**CITY OF ALBUQUERQUE
PLANNING DEPARTMENT
September 30, 2015
DRB Comments**

PROJECT # 1010378 APPLICATION # 15-70345

RE: Lots 10A & 10B, Candelaria Plaza Addition

PROJECT: 1010378  
 DATE: 8-5-15  
 APP: 15-7026d  
 REQUEST: SK

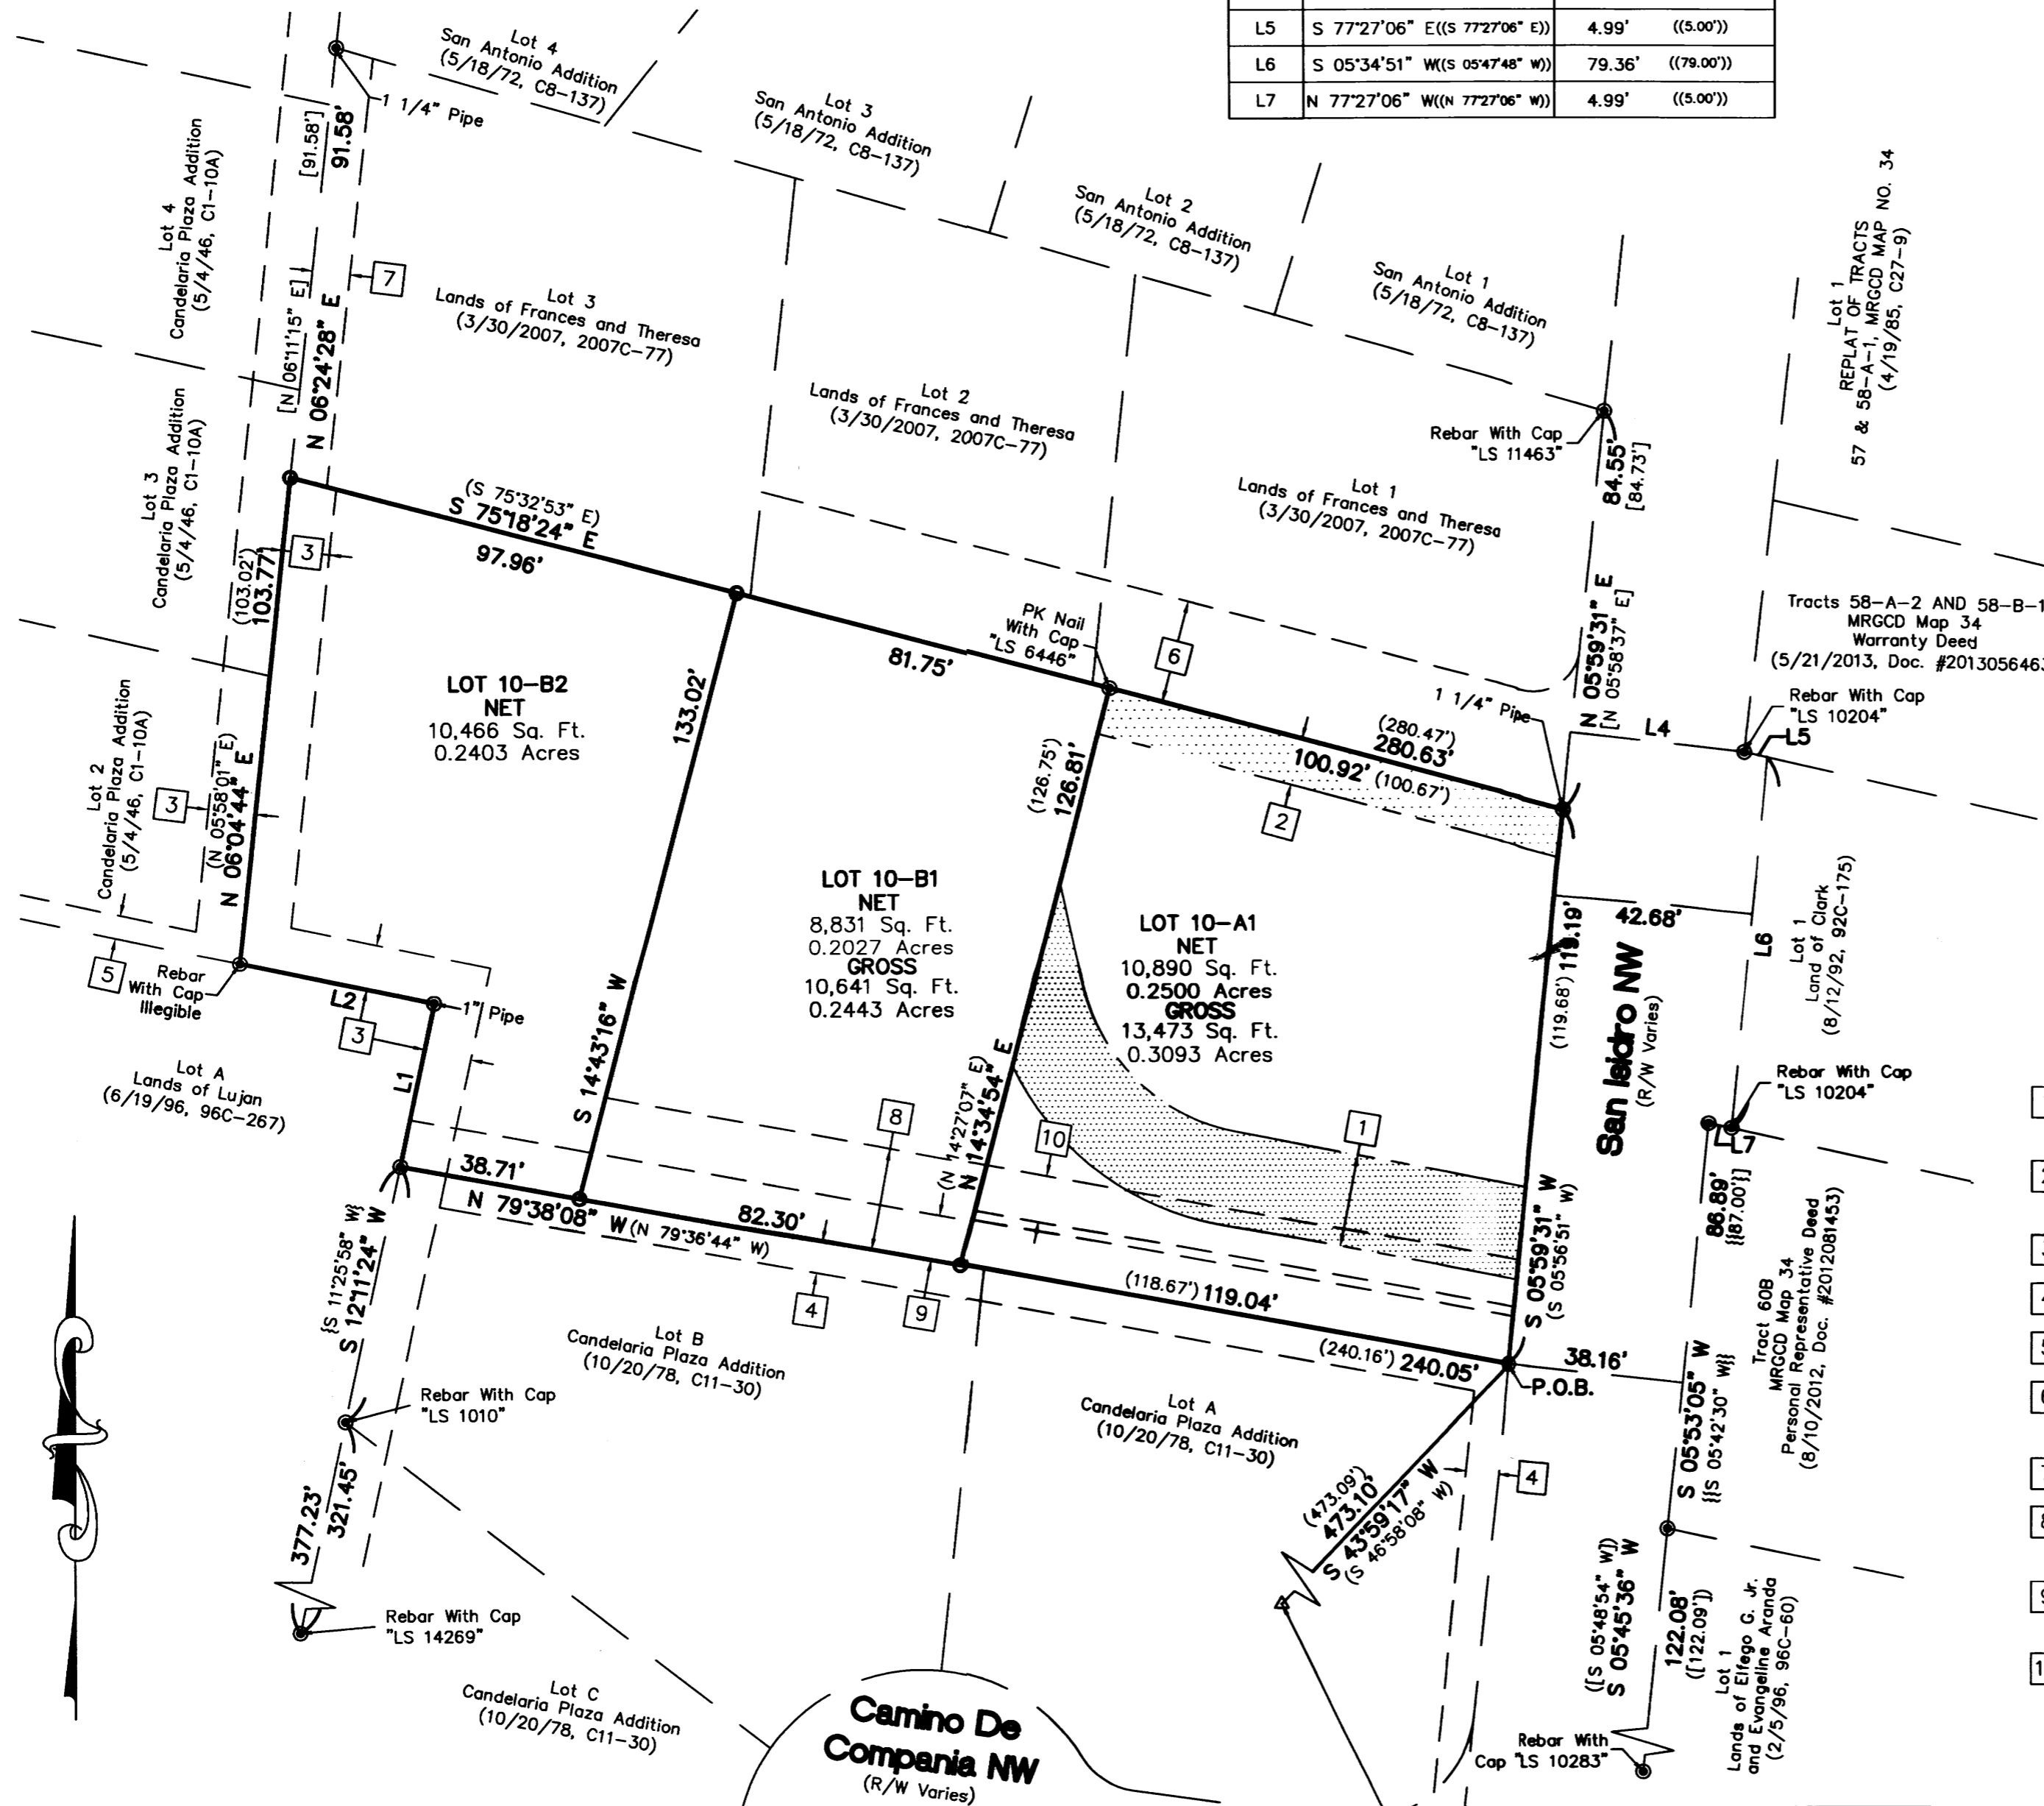
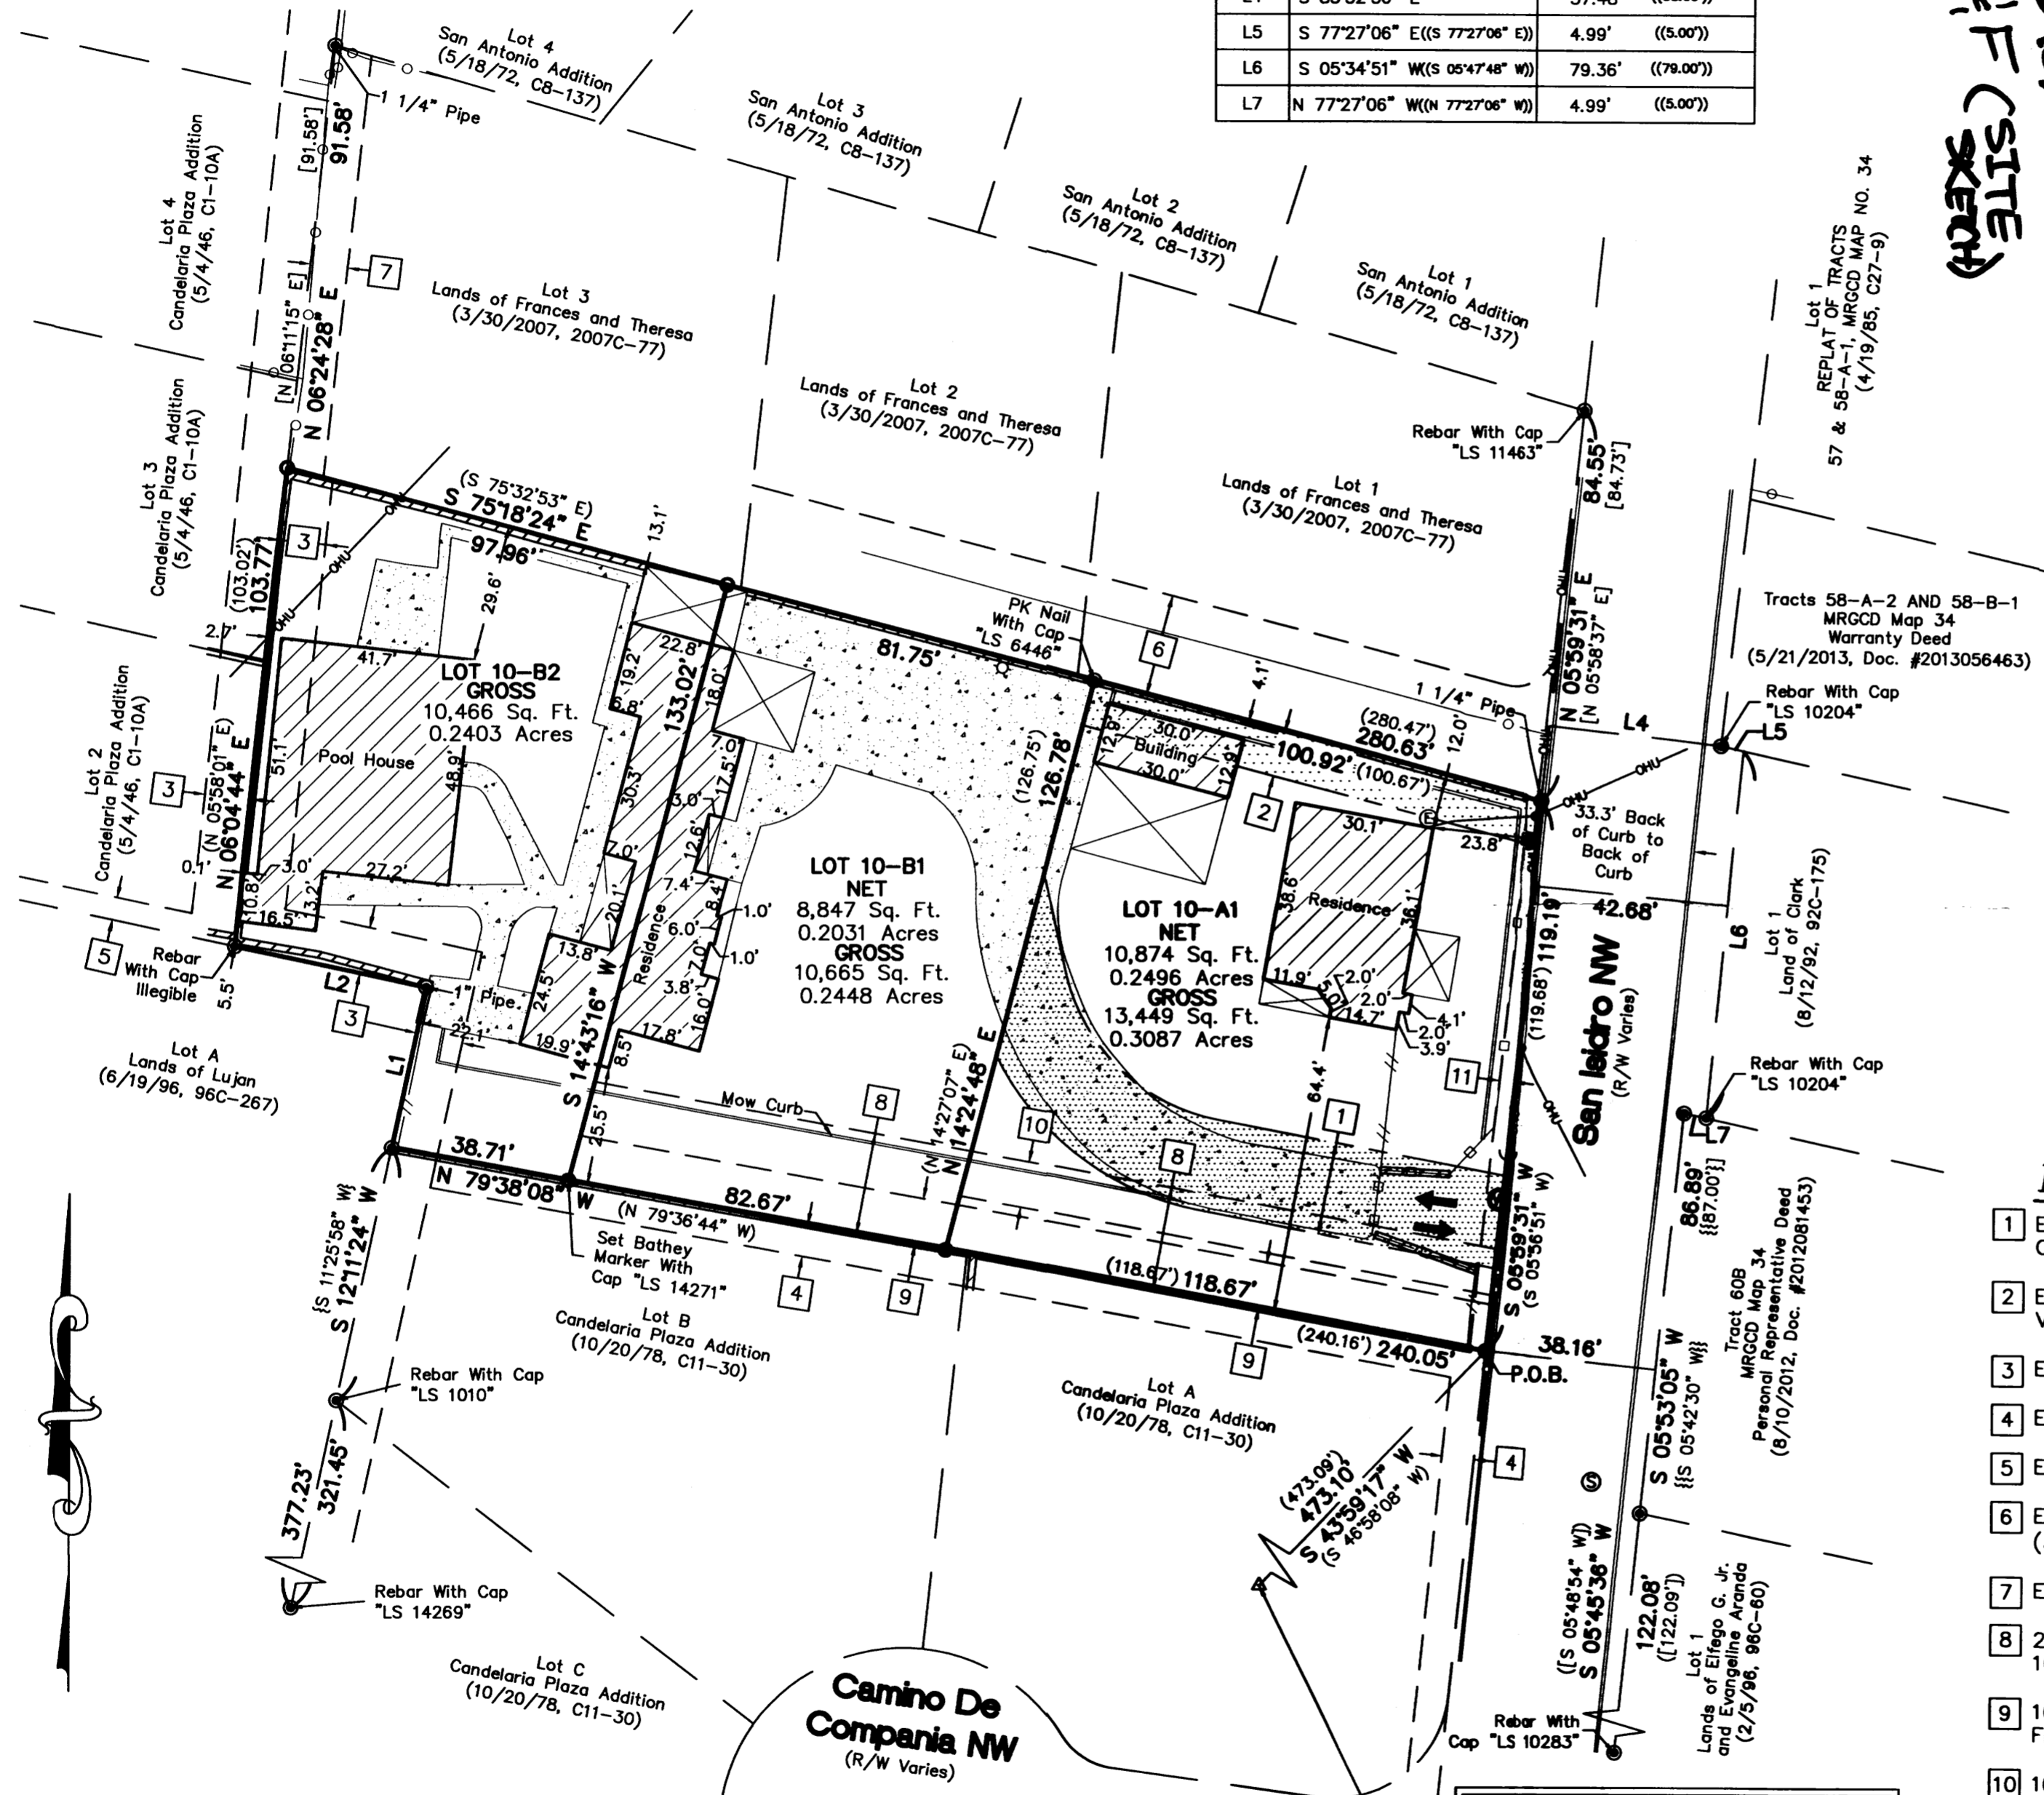
Minimum Access Easement width for 2-3 lots is 22 feet. Private Water and Sanitary Sewer Service Easements will be required for proposed two rear lots.

RA-2 zoning requires a minimum .25 acre *Net* (*exclusive* of Access Easements). A Lot Area Variance would be required for proposed lot 10 B-2; the Variance for proposed Lot 10 B-1 would need to be amended to allow a variance of approximately 2,044 square feet, or more if the lot line is adjusted for proposed Lot 10 B-2 to meet the minimum 10,890 square feet.
